**Waterfront Construction, Inc.**  
205 NE Northlake Way, Suite 230  
Seattle, WA 98105-6816  
Tel (206) 548-9800 Fax (206) 548-1022  
Contractor's License # WATECI881RS

**Doug Rosen - Dock and Pile Repair**  
**WCI Response to SHL21-002 / SEP21-002 5th Review Letter**

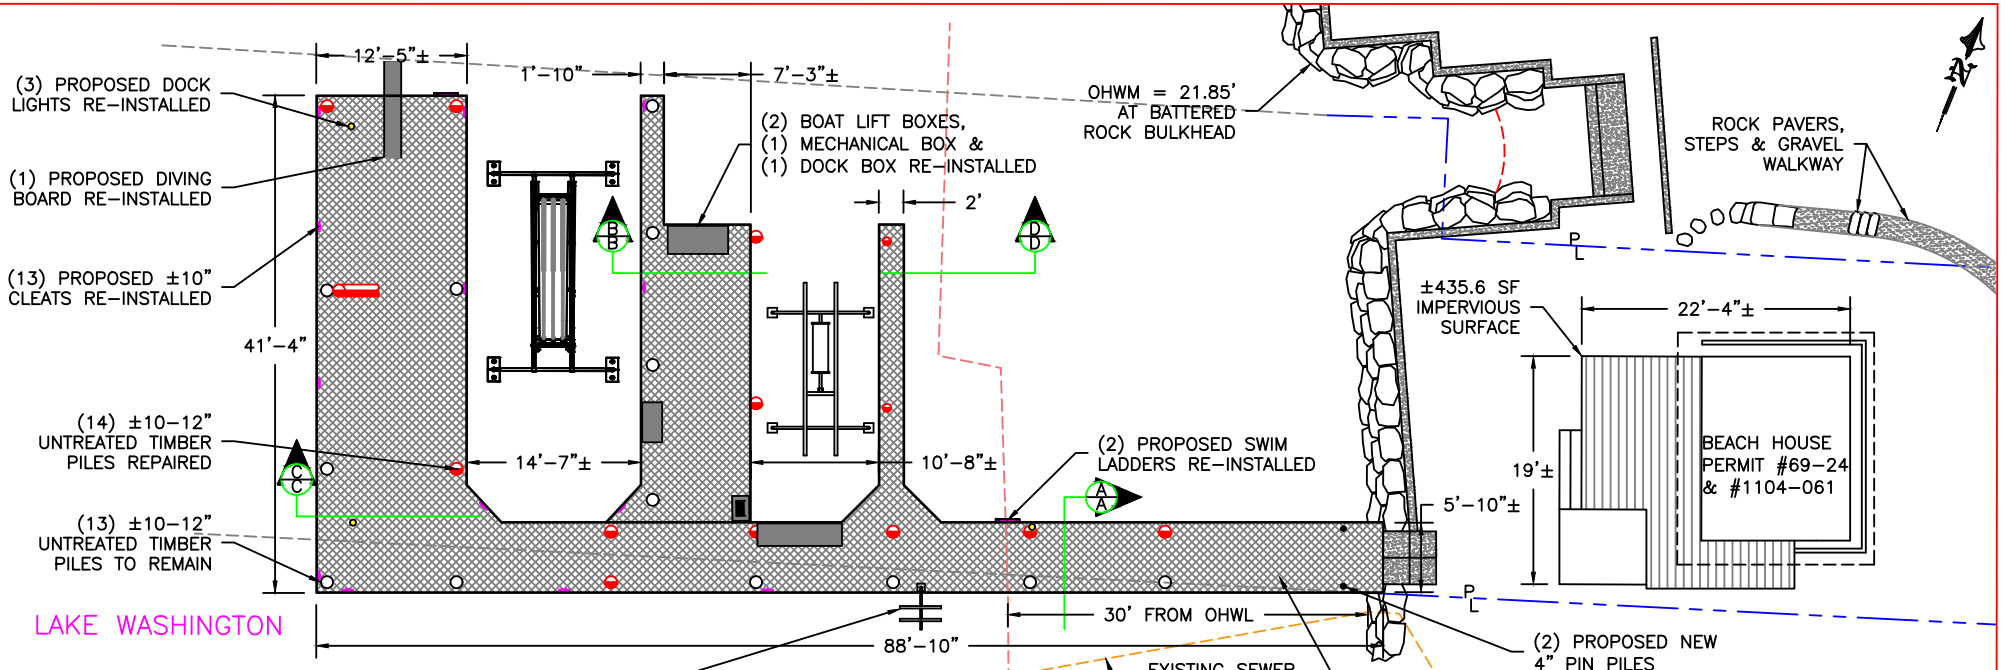
1. The first submittal of this permit included an affidavit stating that the sewer lake line was field located at this site. However, the Sheet 4 of 16 of the plan set shows that the location of the sewer lake line will be field verified prior to building permit approval. Other sheets of the plan set show that the sewer lake line has been field located. Please clarify this discrepancy and show the field-verified location of the sewer lake line and its associated easement on all sheets of the plans.

[WCI response: Plan set has been revised, please see page 4.](#)
